Date 13th January 2021

Town and Country Planning Act 1990 as amended
Oxford Retail Park, Ambassador Avenue, Oxford
Section 73 application to amend elevational details, Oxford Retail Park, ref 19/03236/FUL

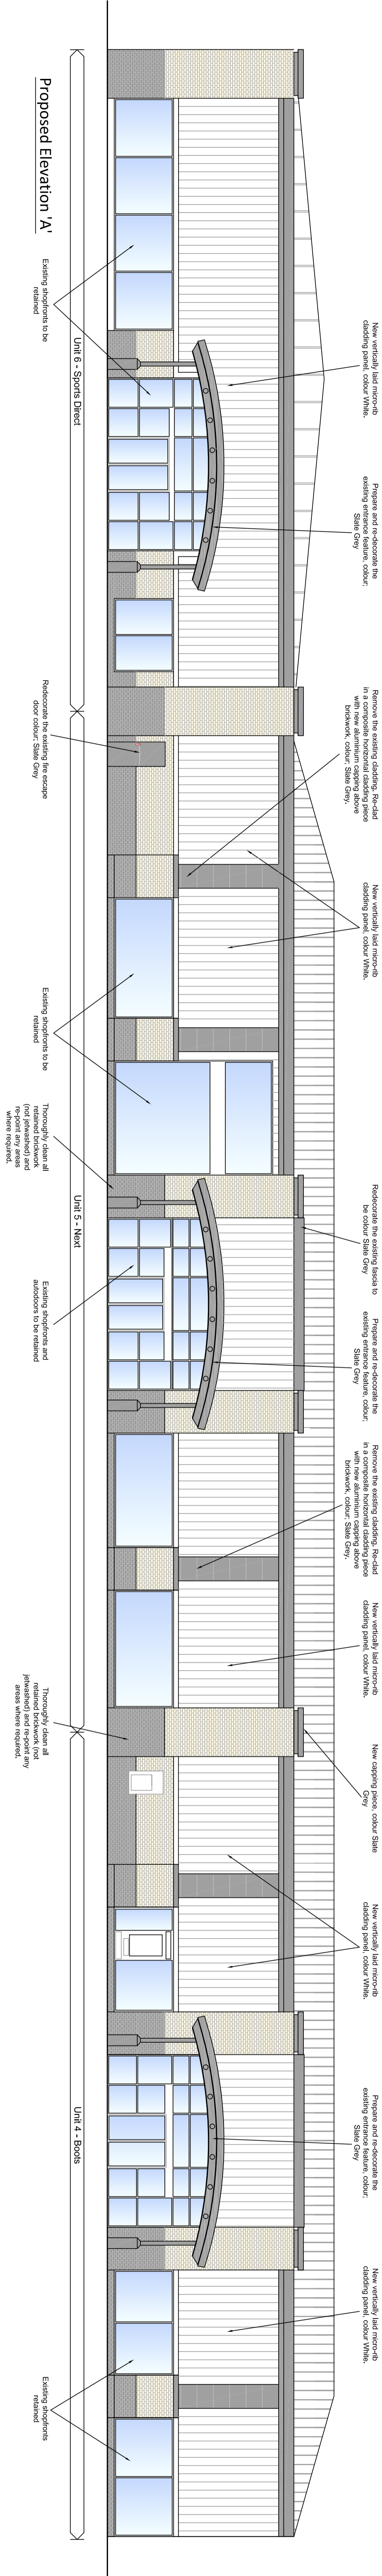
1. New vertical cladding specification to the front elevations – I have attached a photo showing the proposed material. Note, these are shown in a horizontal configuration, but we will be laying them vertically. The colour will be RAL 9003 (Signal White);

2. The previously shown new glazing to M&S, Boots and Next is omitted. Their existing glazing is to remain;
3. The entrance features to M&S, Boots and Next are to remain as existing and be redecorated RAL 7015 (Slate Grey);

4. The existing fascia is to be retained and redecorate RAL 7015 (Slate Grey);
5. The external 'columns' currently shown proposed clad in a horizontally laid cladding panel are altered to have the new cladding panel at the upper level only. This avoids having to adjust the existing brickwork at low level thus causing disruption to the trading Tenants. The colour of this cladding will be RAL 7015 (Slate Grey);

6. The proposed glazing and cladding arrangements to the former Mothercare have been amended to suit the incoming Tenants requirements;
7. New fire escape door on the side elevation of the former Mothercare (elevation C); and

8. Infilling of redundant fire escape doors to the rear of the former Mothercare (elevation D).

The latest proposed cladding as shown on our drawings is a 300mm wide micro-rib panel which will be vertically laid as previously shown. The only variation over the Mountford Pigott's drawings is the panel width (previously shown as circa. 1000mm wide). The cladding profile and colour remains the same.
